**Canal &
River Trust**

Your Ref 2023/91893

Proposal: Removal of existing garage and link structure and erection of two and a half storey side extension, raised terrace and single storey garage with garden store below.

Location: 78 Marsden Lane, Marsden, Huddersfield

Proposed Site Layout
Scale 1:200

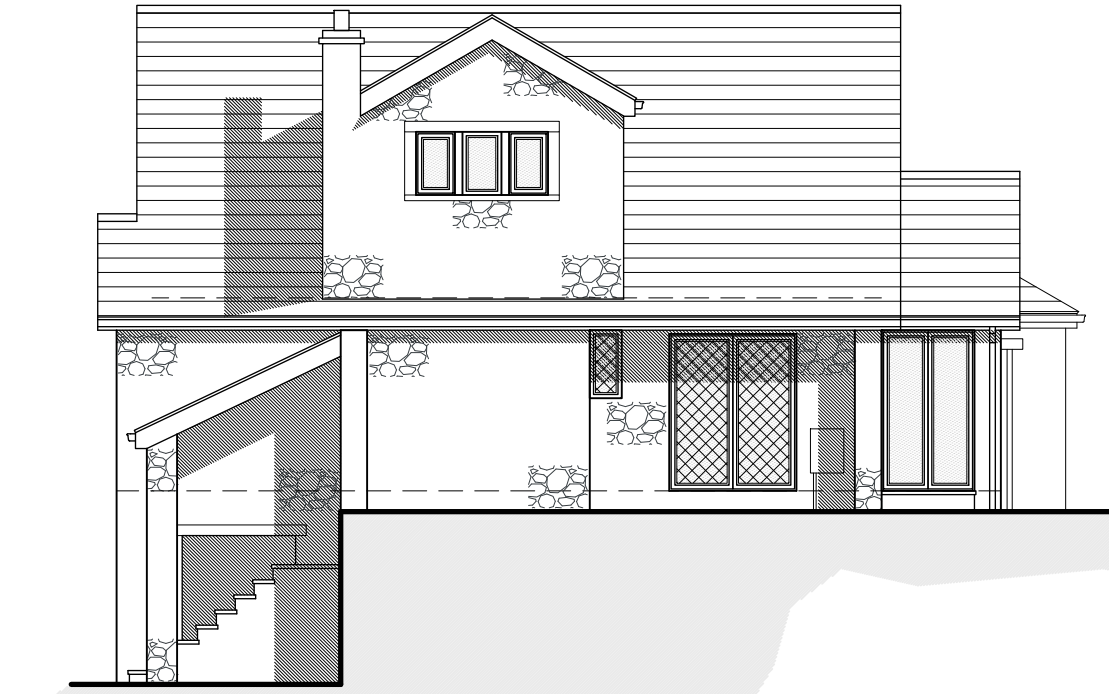
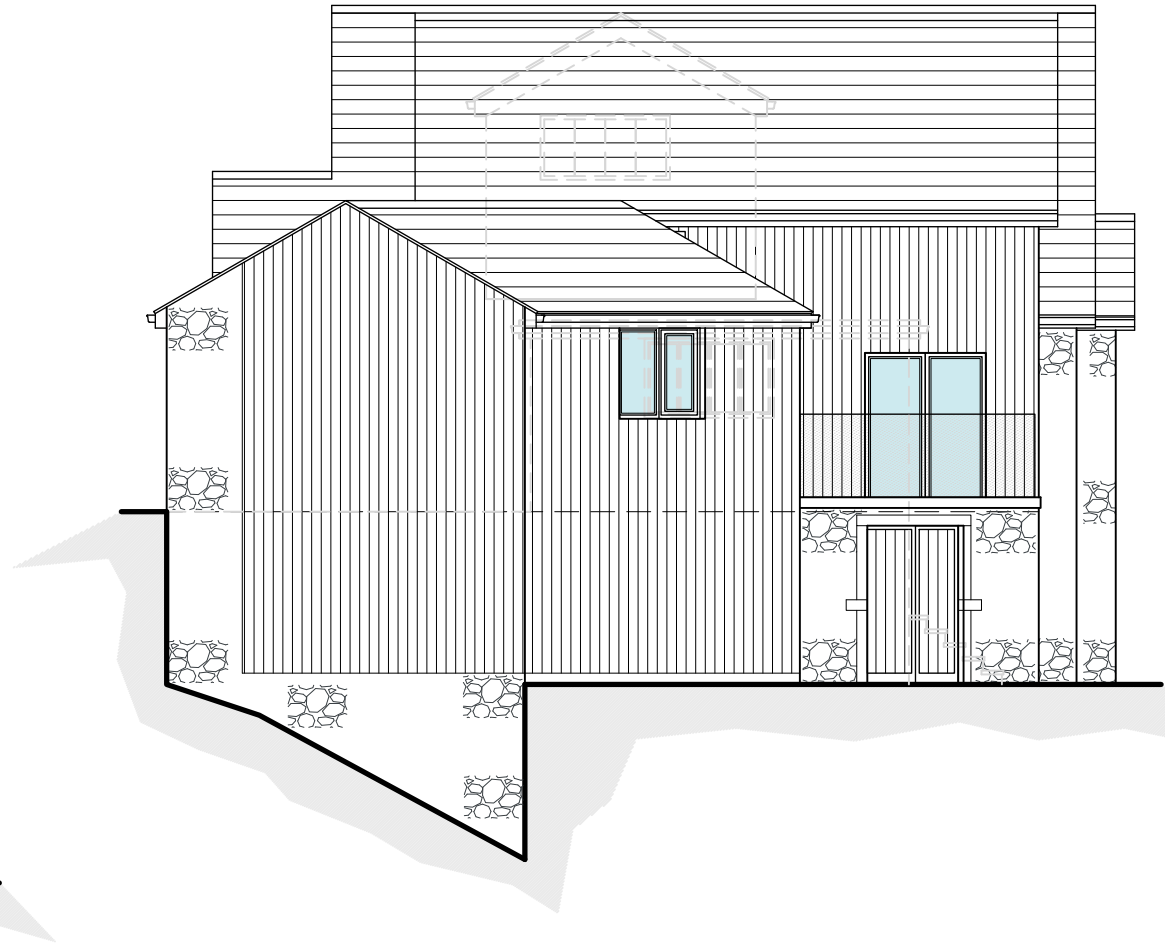
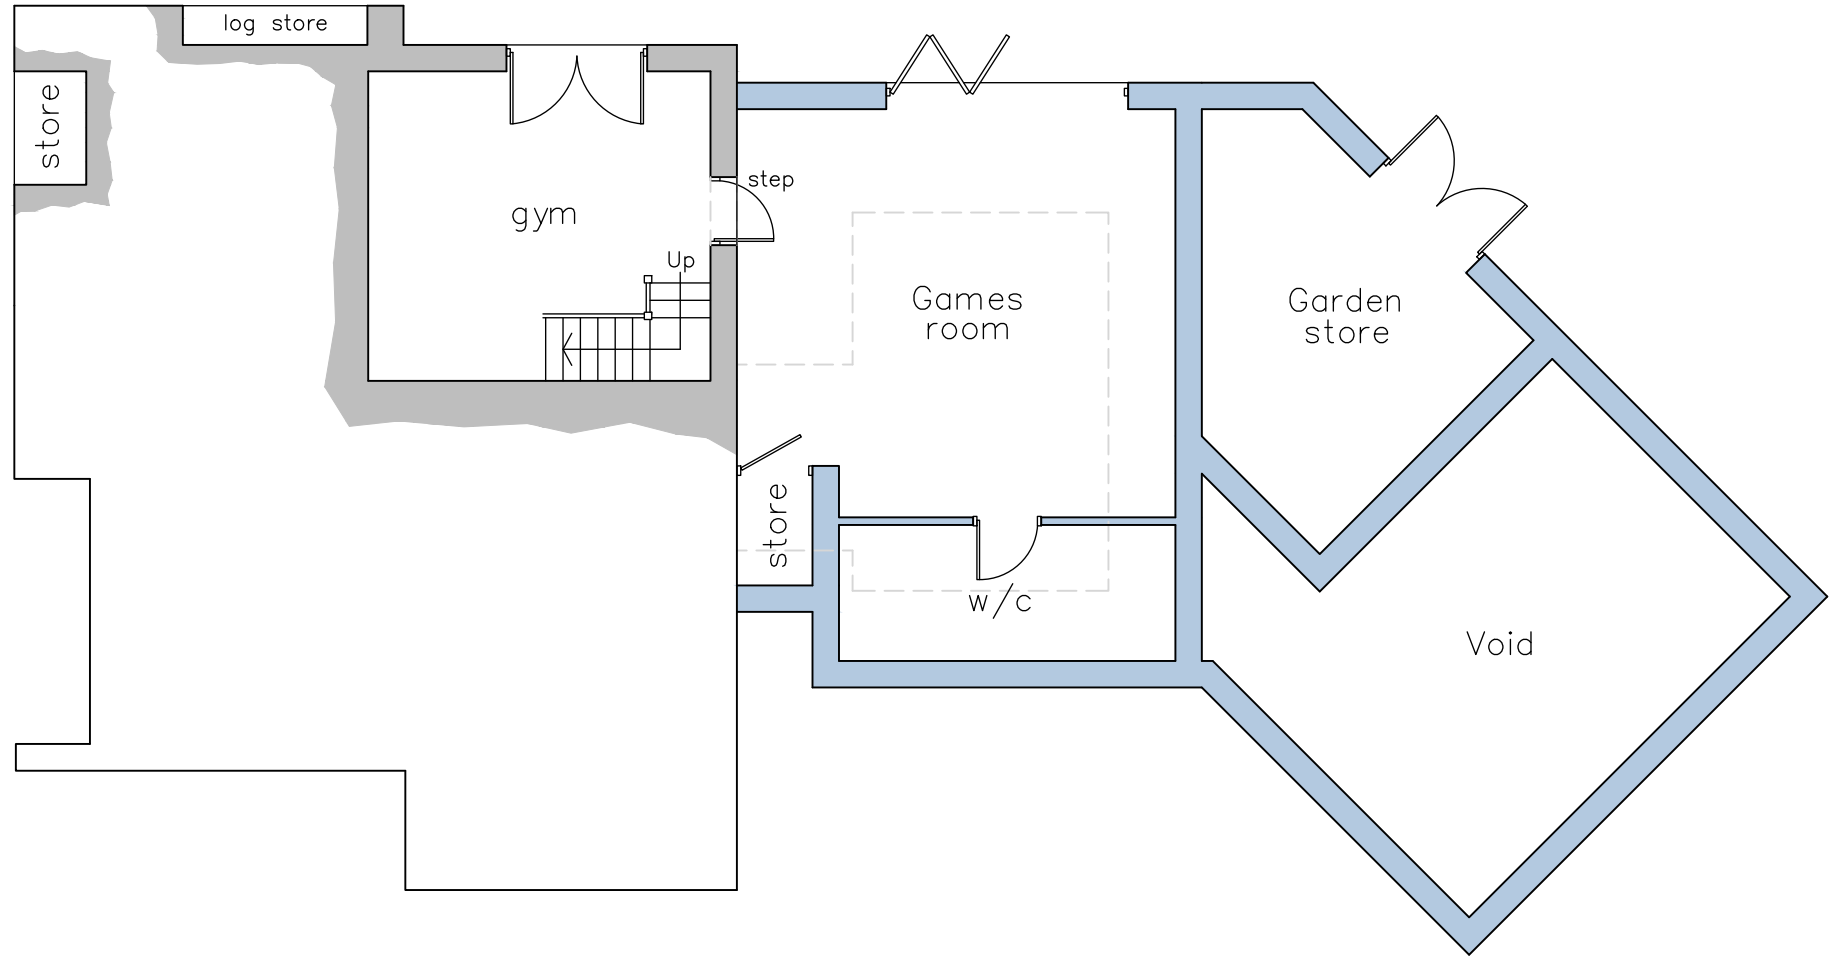
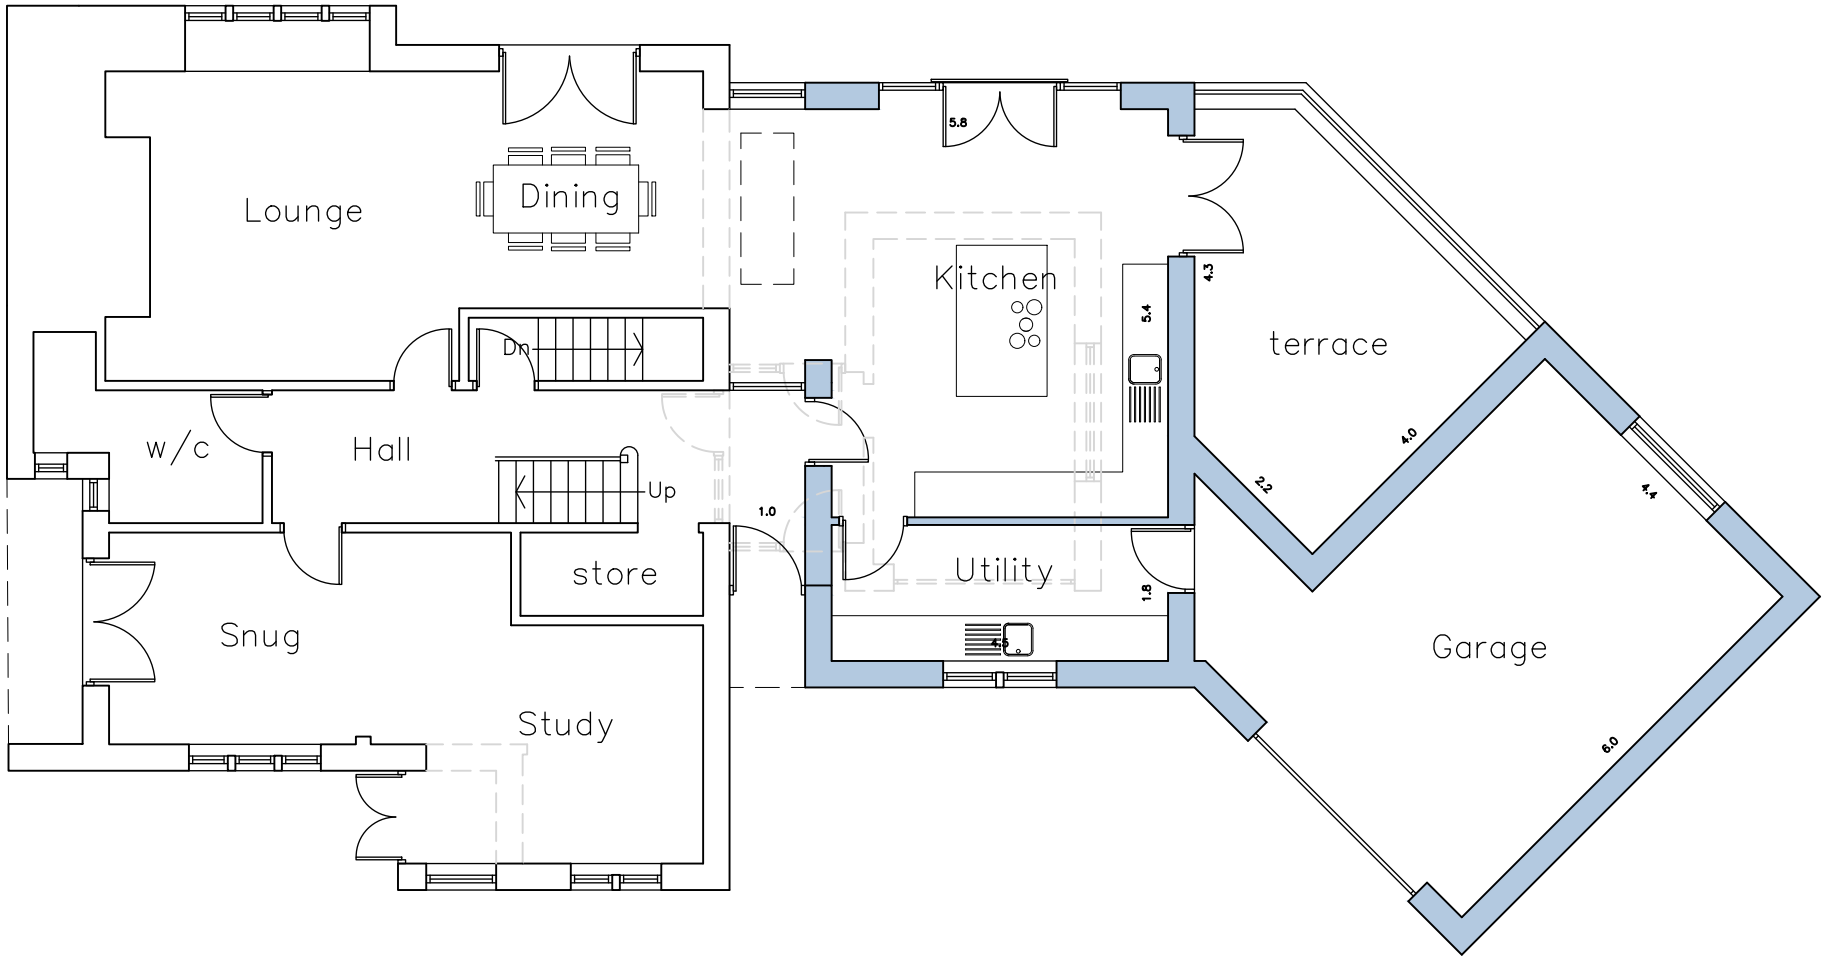
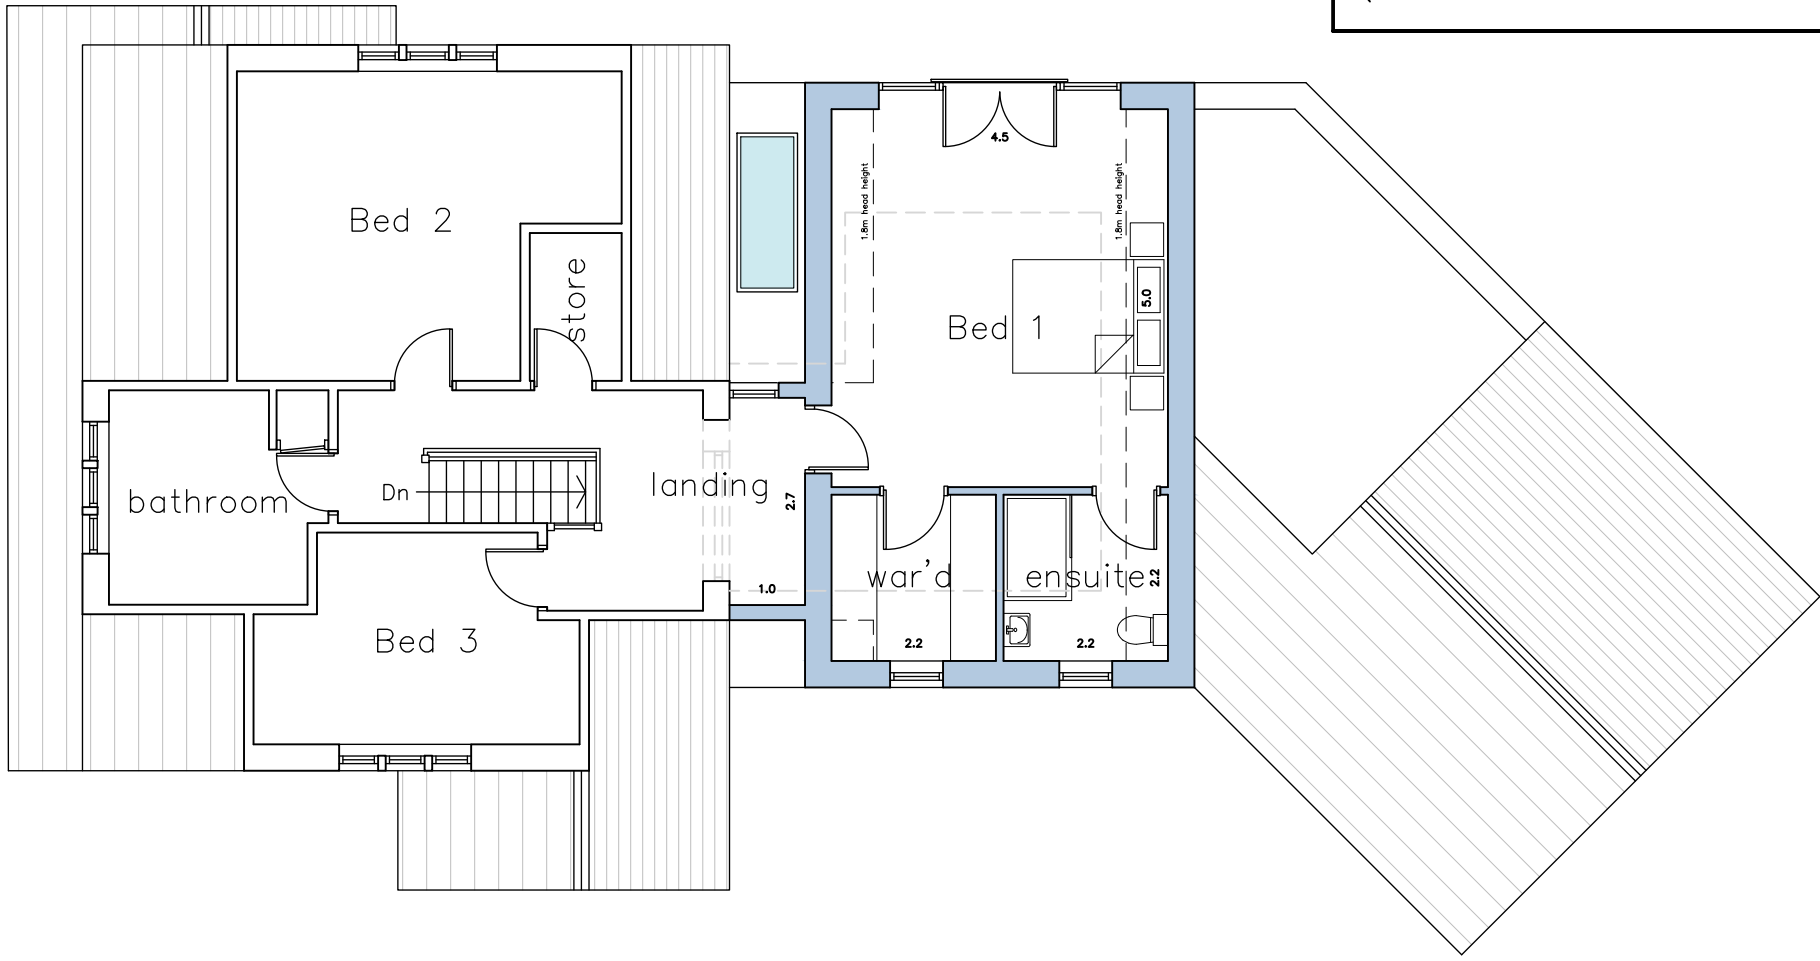
The Trust own and manage the Huddersfield Narrow Canal, located to the south of the application site. The site is on sloping land, which forms part of the cutting slope to the canal.

The Trust's most recent inspection of the cutting slope identifies that water runoff onto or seepage into the slope could lead to deterioration of this asset, which could increase the long term risk of land instability towards the canal.

To address the above risk, prior to the approval of the application, **we request that the Local Planning Authority seek confirmation from the applicant that drainage from the extension will not discharge onto the cutting slope, including to any nearby soakaway structures.**
